CITY OF PORTLAND BUILDING PERMIT

Located At 727 CONGRESS ST

Job ID: 2012-04-3743-CH OF USE

has permission to Convert 8 apartments into 8 Single Family Condominiums, same use, new ownership – no construction provided that the person or persons, firm or corporation accepting this permit shall comply with all of the provisions of the Statues of Maine and of the Ordinances of the City of Portland regulating the construction, maintenance and use of the buildings and structures, and of the application on file in the department.

0 | LOWER LEVEL FLOOR PLAN
SCALE: 1/4"=1'-0"

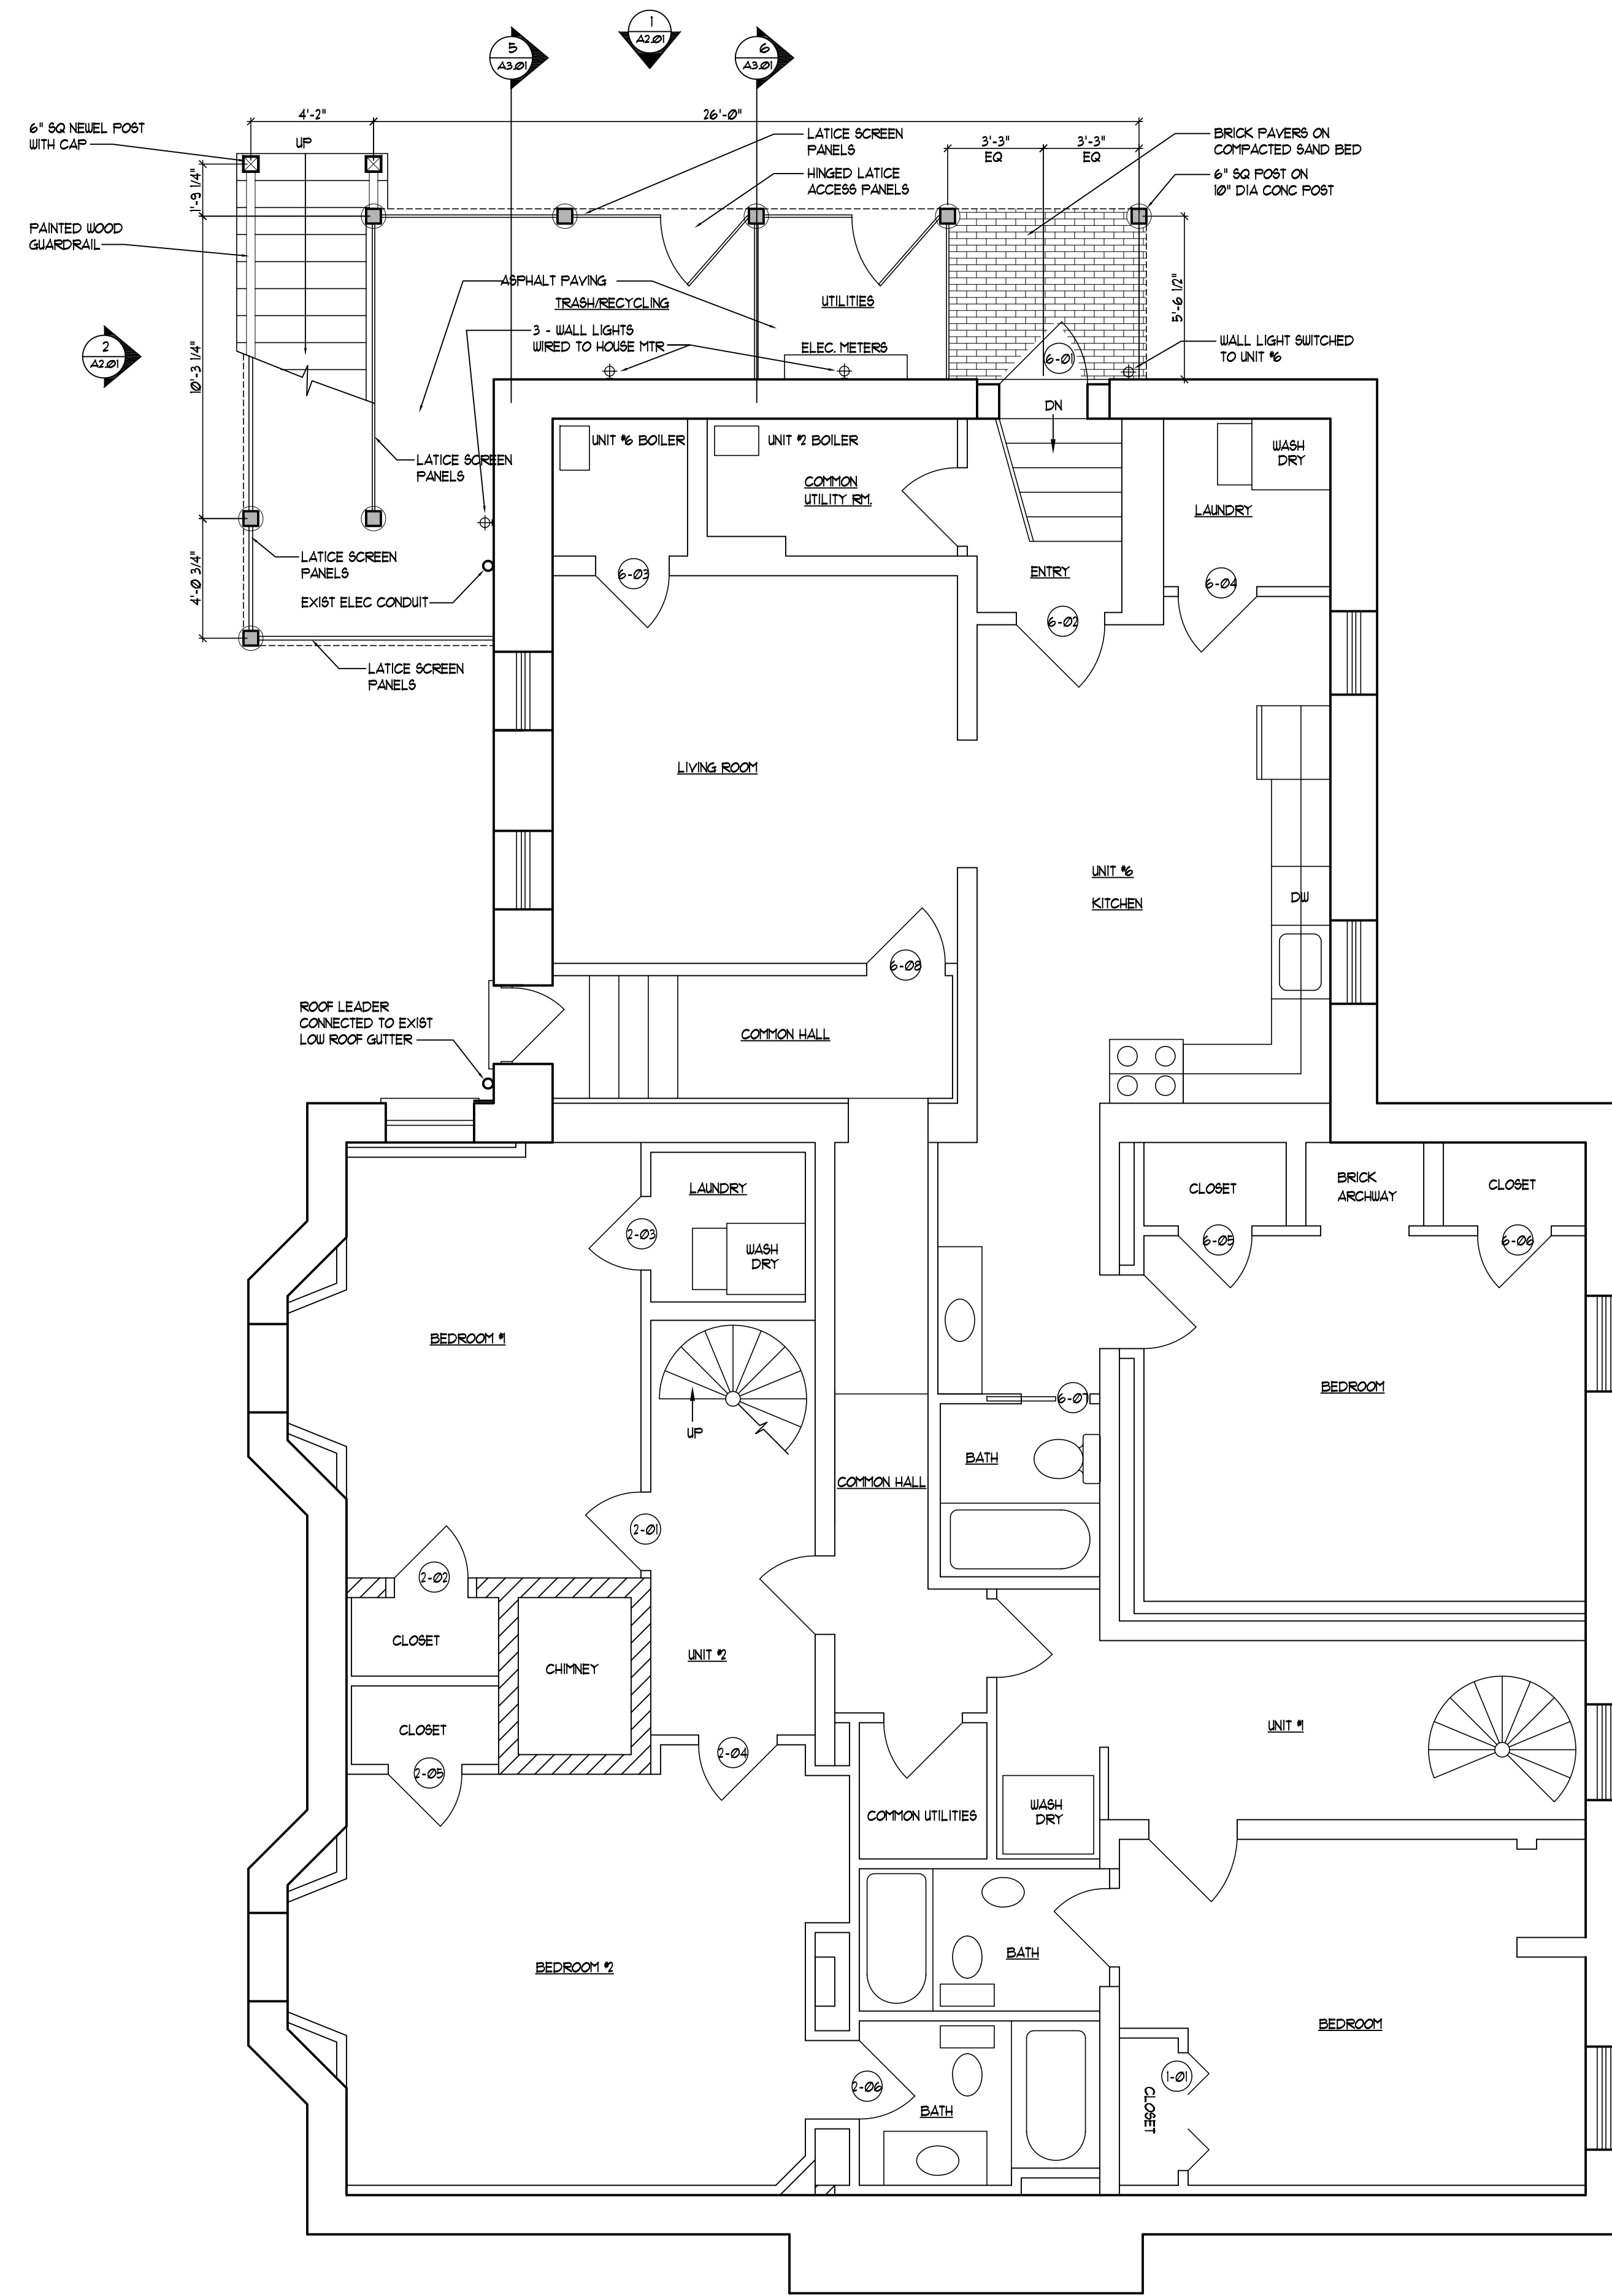
Basement Mech room
2 Dimmer switches are overloaded. Provide appropriate switches/enclosure
Label panels, ELights & signs
Remove extension cord, provide outlet to #2 boiler and show where extension cord was connected

Unit 1 - Basement:
Provide CO detection
Door swing to hall is reversed (as per plan) and blocks corridor (existing)

Basement corridor & gas meter room
Dryer vent needs rated separation
Provide:
Handrail in hall and stair to second exit
E-light in common area

**4** FOURTH FLOOR PLAN  
SCALE: 1/4"=1'-0"

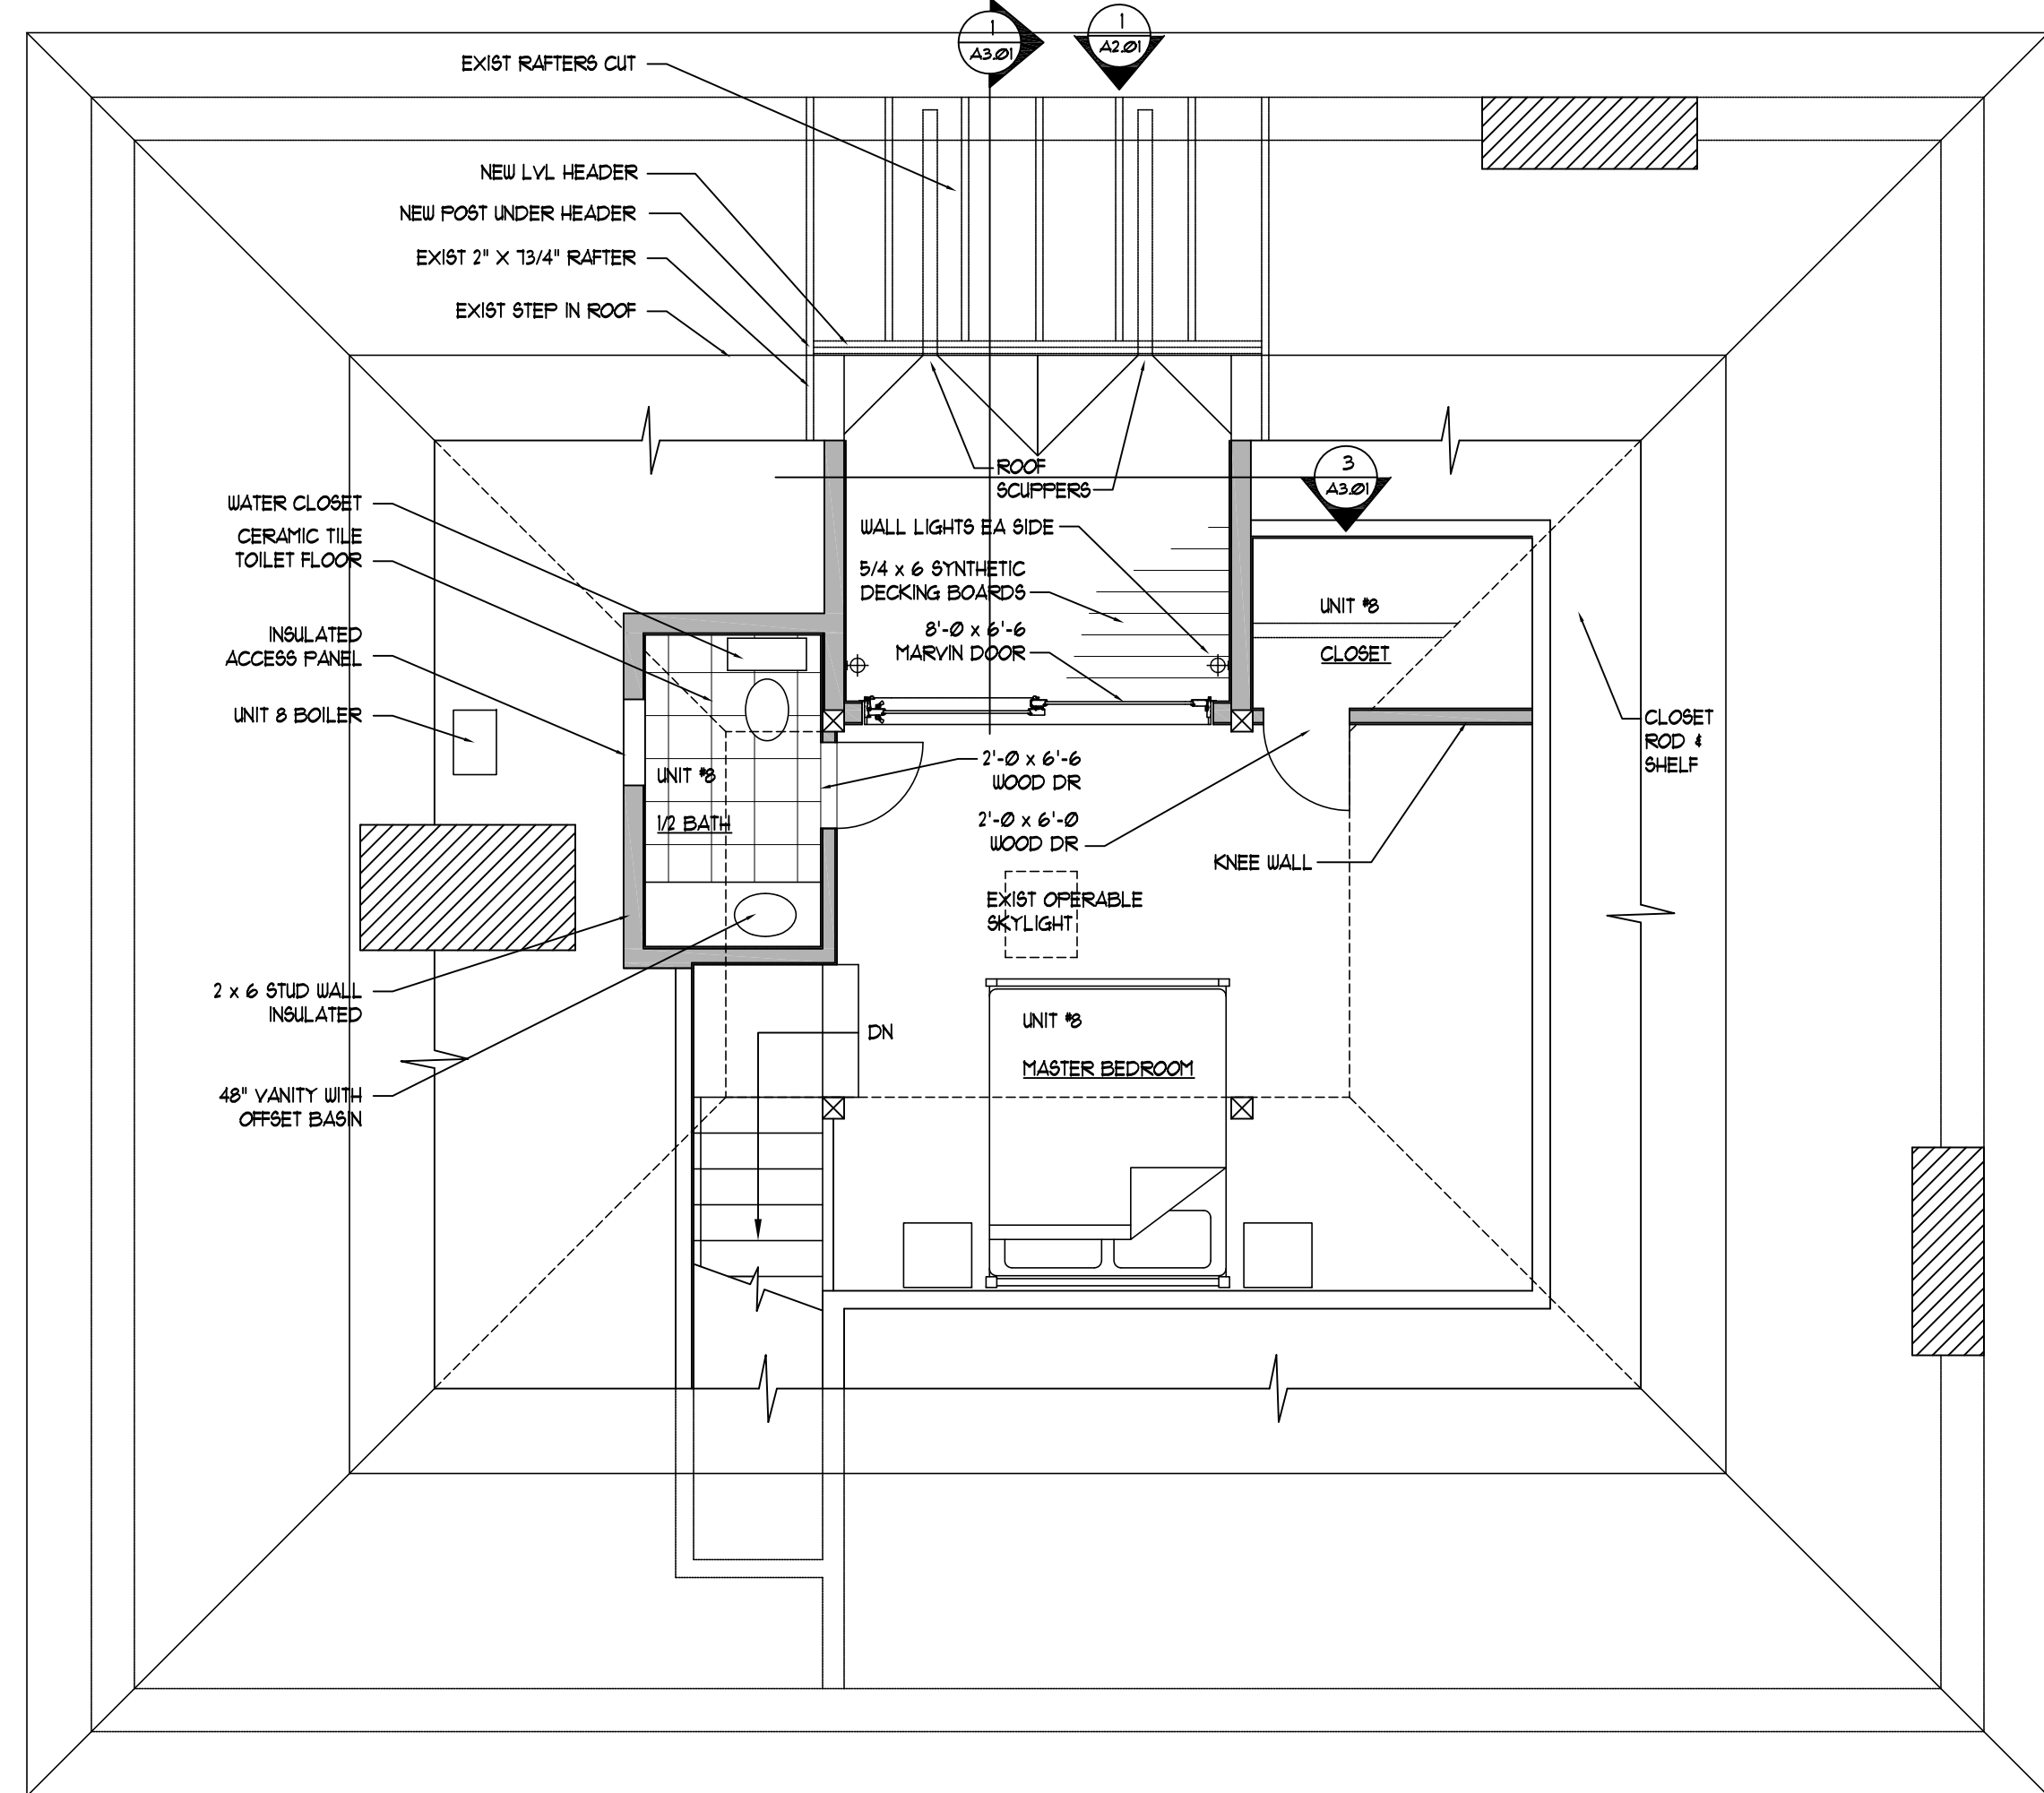
Unit 8 - 4th floor Deck
Show results of close-in inspection
Guard rail to be 42" minimum with max 4" openings
